From: Kate Smith <kate.smith@penrith.city>
Sent: Tuesday, 7 June 2016 8:53 AM
To: Thomas Piovesan
Cc: Robert Craig
Subject: Oakdale South Industrial Estate (SSD 6917) - Applicant's Response to Submissions

RE: State Significant Development Proposal No. 6917 – Oakdale South Response to Submissions (RTS)

I refer to the Department's letter received on 20 May 2016 seeking Council's comments on the Applicant's Response to Submissions (RTS) for State Significant Development Proposal No. SSD-6917.

Figure 9: Southern (Bottom) and Eastern (top) Noise Walls and Setback Sections

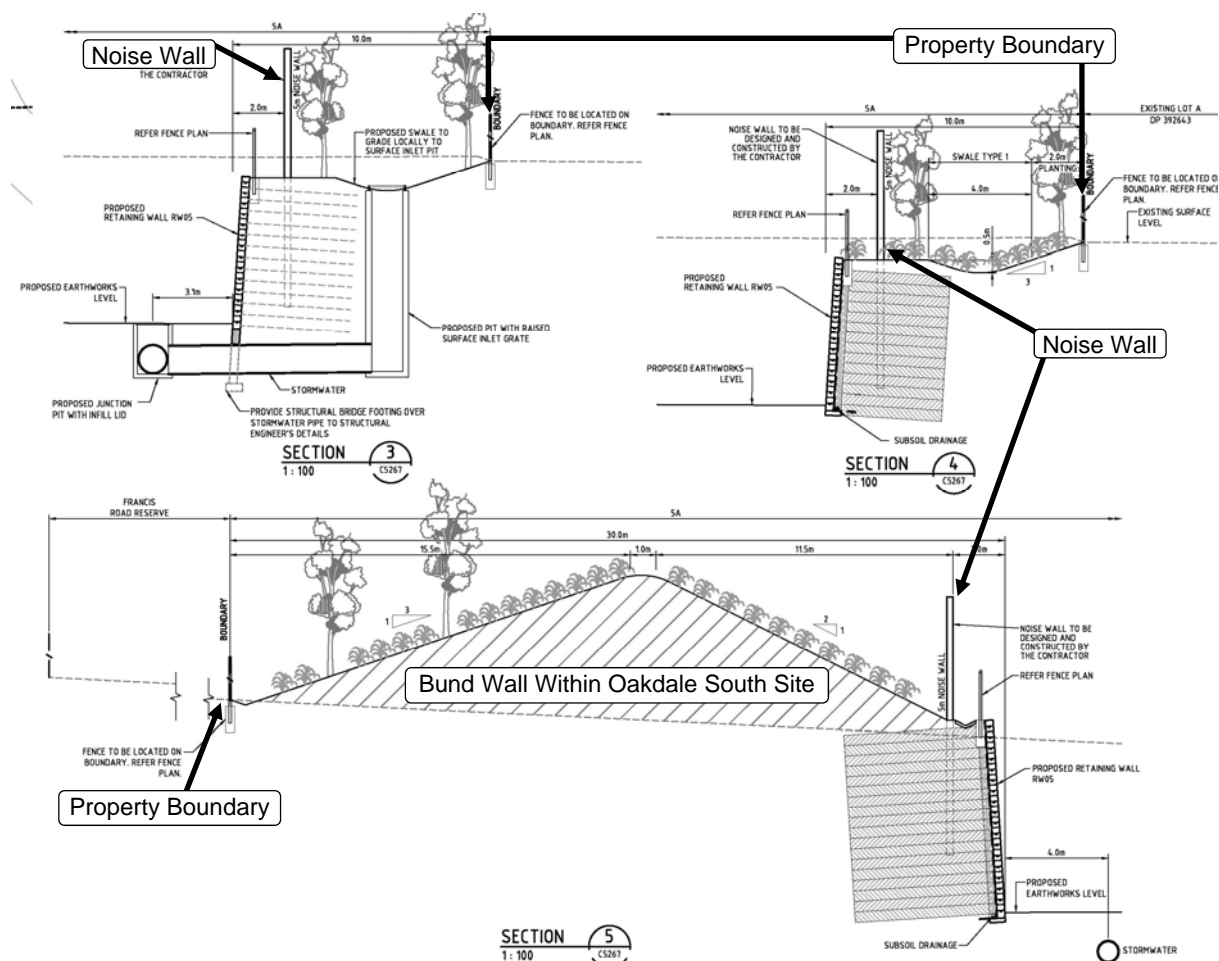
Largely the issues raised in Council's submission have been adequately addressed by the applicant. However, Council remains concerned regarding the extent to which the proposed setback and acoustic wall treatments to the south and east will provide an appropriate level of separation and transition between the adjacent industrial buildings and rural-residential developments, both existing and future.
